Rezoning Transportation Analysis
Petition Number: Insert Zoning Petition #2021-018
General Location Identifier: Tax ID 07908301

Reviewer: Eric Lemieux, PE
 Eric.Lemieux@charlottenc.gov
 704-336-2683

Revision Log:	Date	Description
	02-25-21	First Review (EL)
	03-25-21	Second Review (KP)

RZ-2

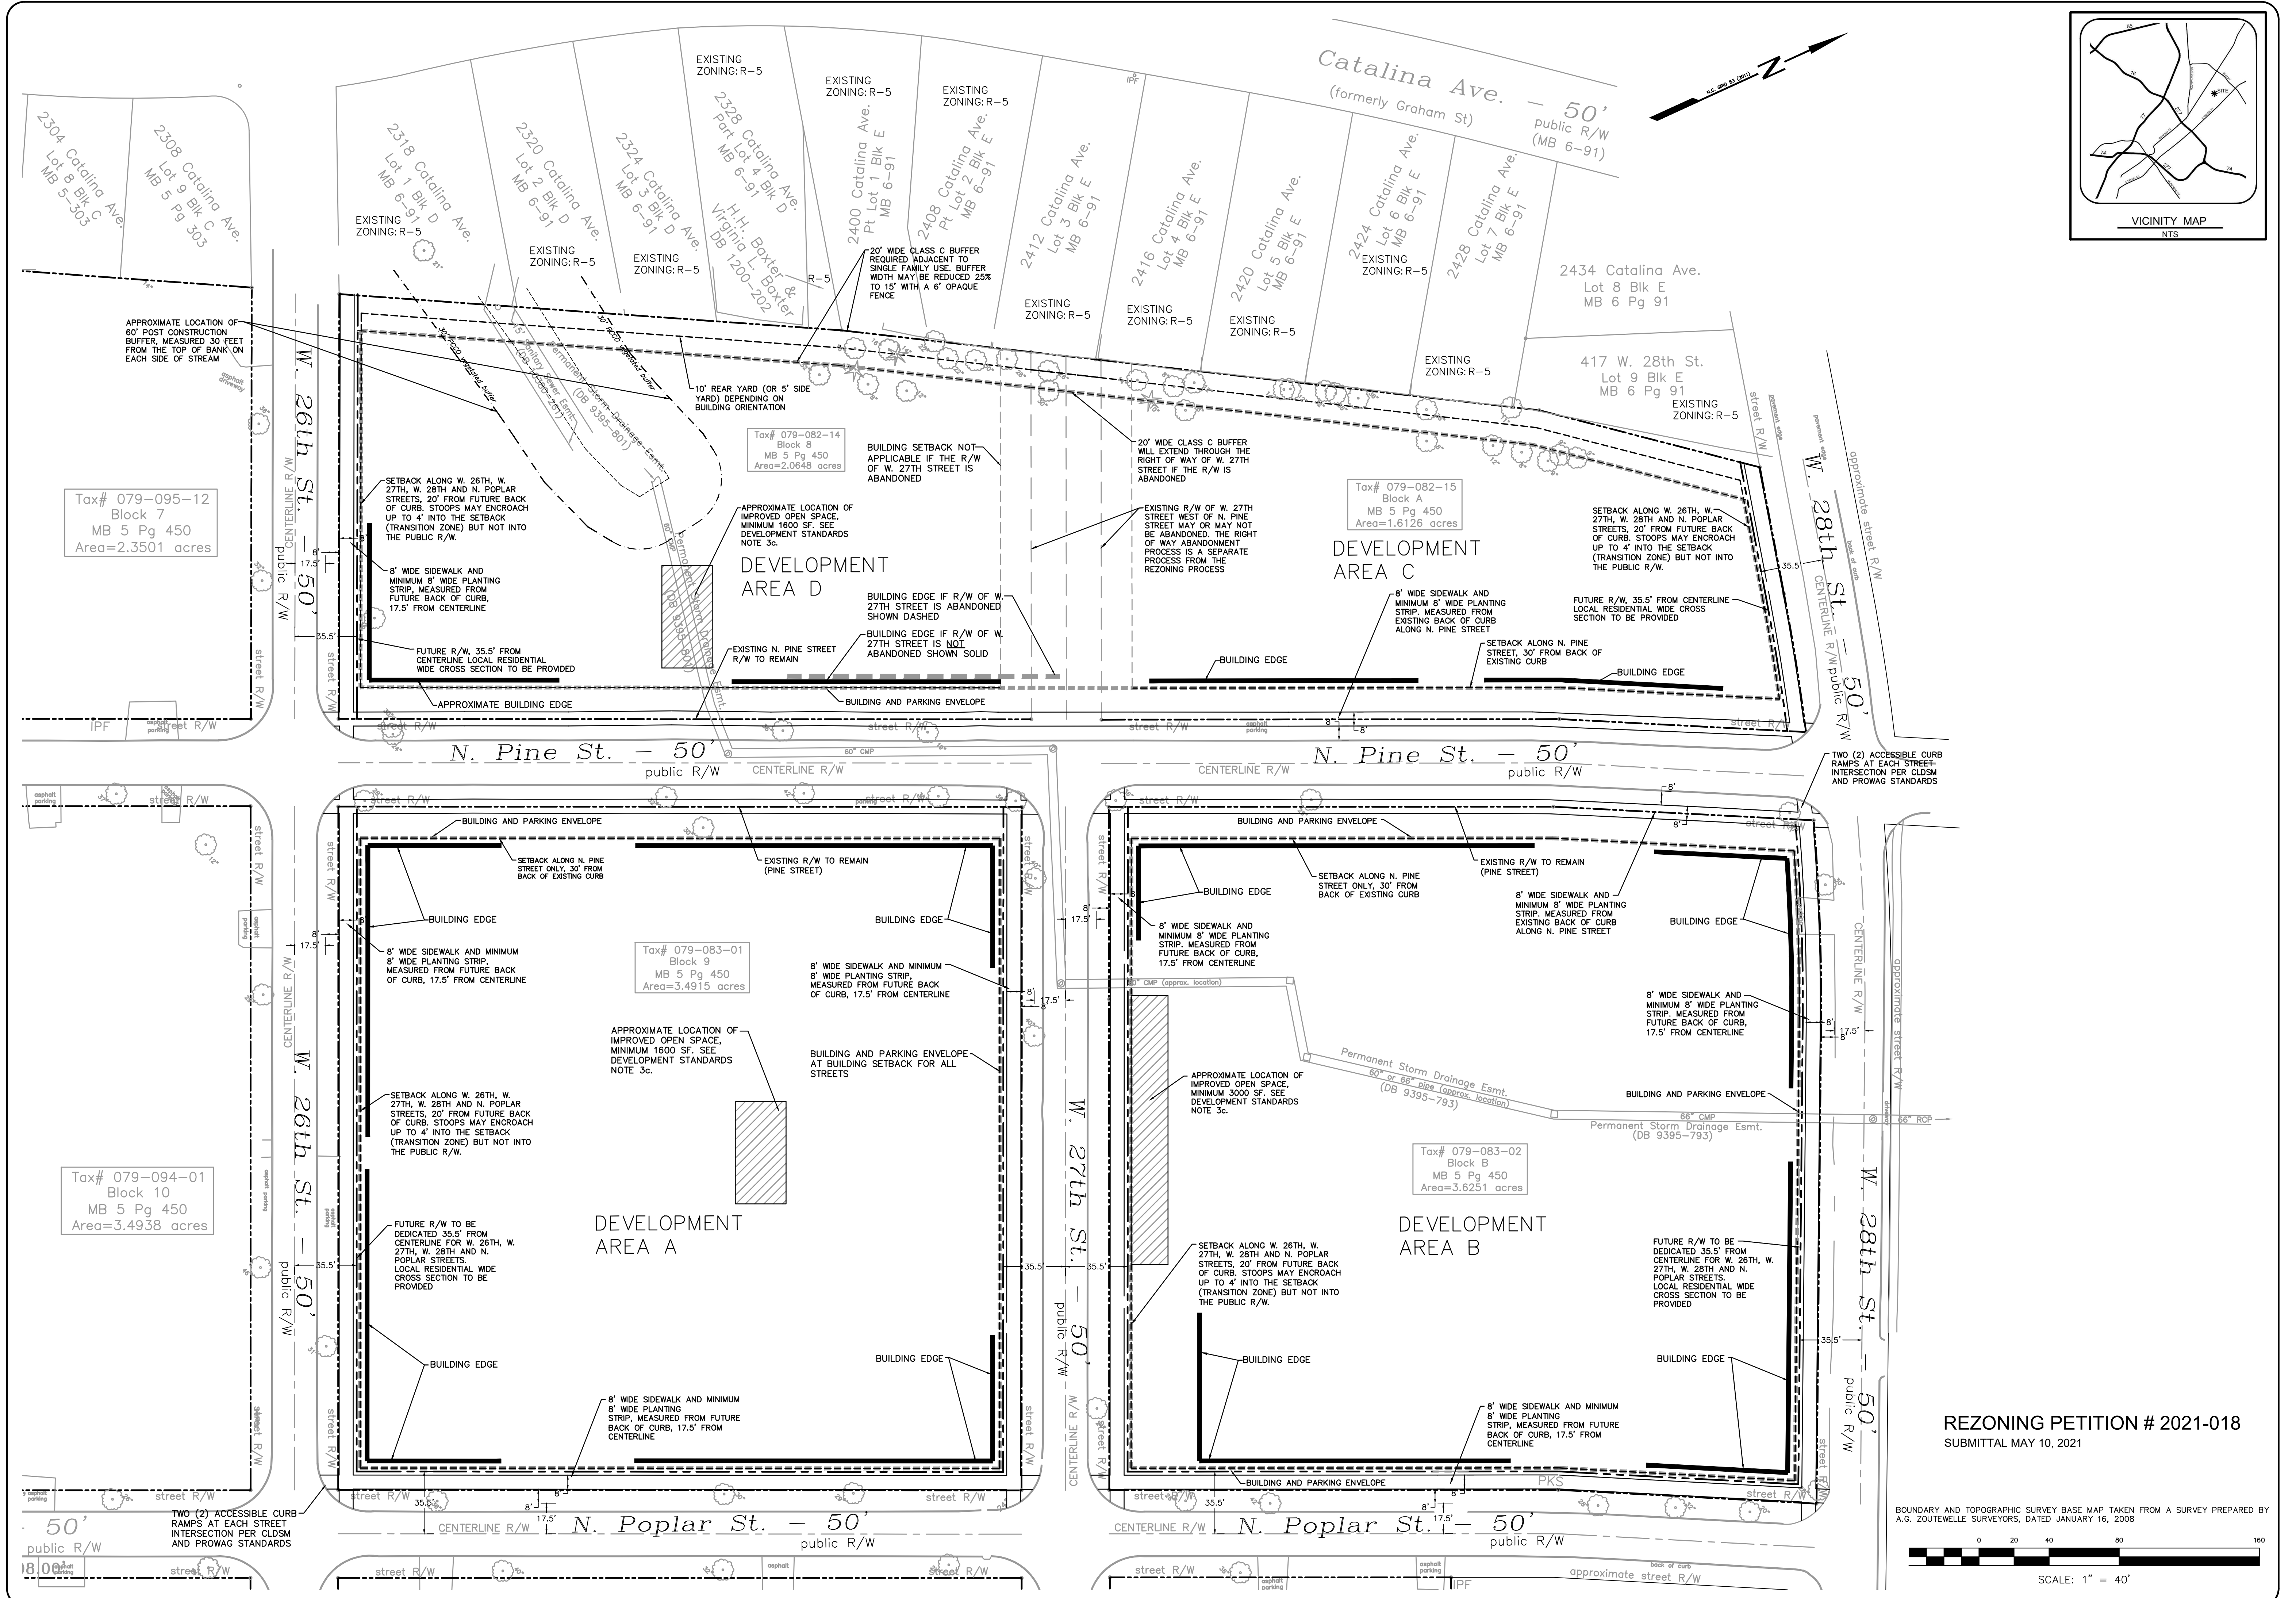
5. ~~A site plan note specifying dedication and fee simple conveyance of all rights-of-way to the City before the site's first building certificate of occupancy is issued is needed. CDOT requests rights-of-way set at 2' behind back of sidewalk where feasible.~~
6. ~~A site plan note specifying that all transportation improvements will be approved and constructed before the site's first building certificate of occupancy is issued is needed. The petitioner may phase transportation improvements if said improvements and phasing are explicitly described in site plan notes.~~
7. On sheets RZ-1 and RZ-2, remove call-out to abandon and remove W. 27th Street. Also, remove the site conditional note 3. Access, Buffers, Screening, Open Space and Pedestrian Circulation, Note I. The abandonment of W. 27th Street is not consistent with the USDG Standards (see image below).

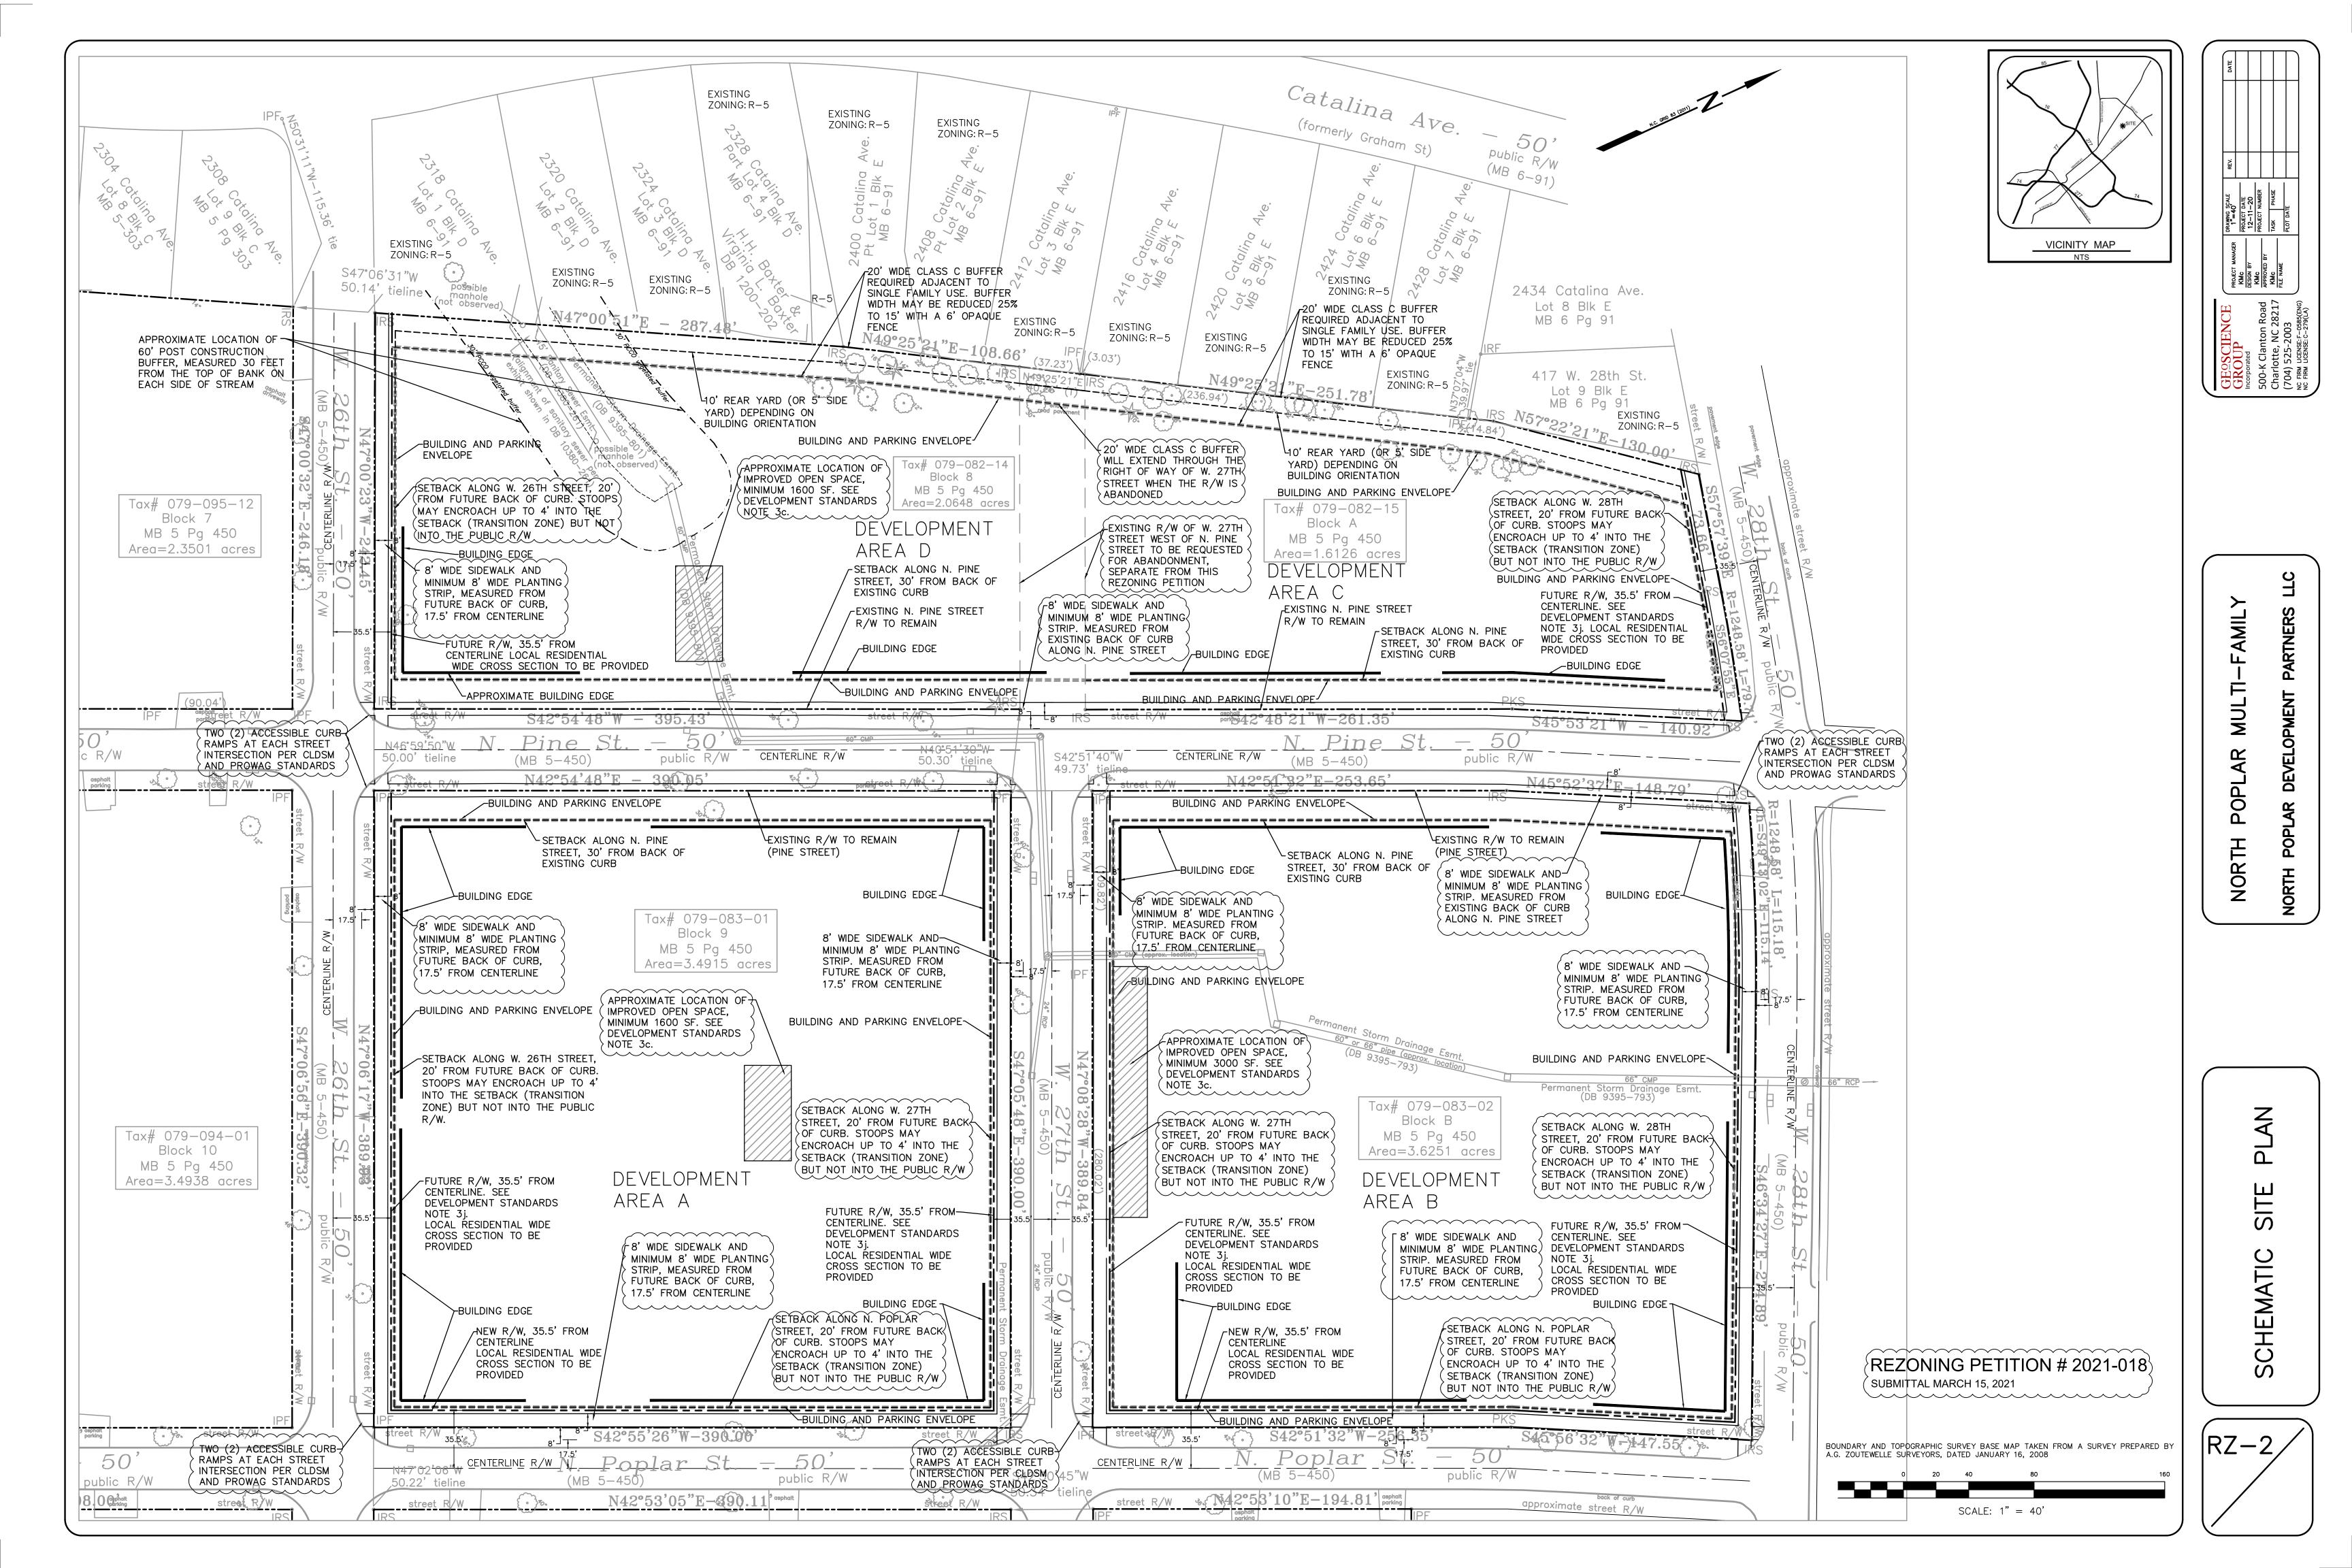
Update to Comment as a Result of 03/16/2021 Site Plan: Add a conditional note that recessed on-street parking will be provided along all street frontages in accordance with CLDSM.

Update to Comment as a Result of 03/16/2021 Site Plan: Remove note 3.K. This is covered in the site plan call-out, and is a separate process from the rezoning.
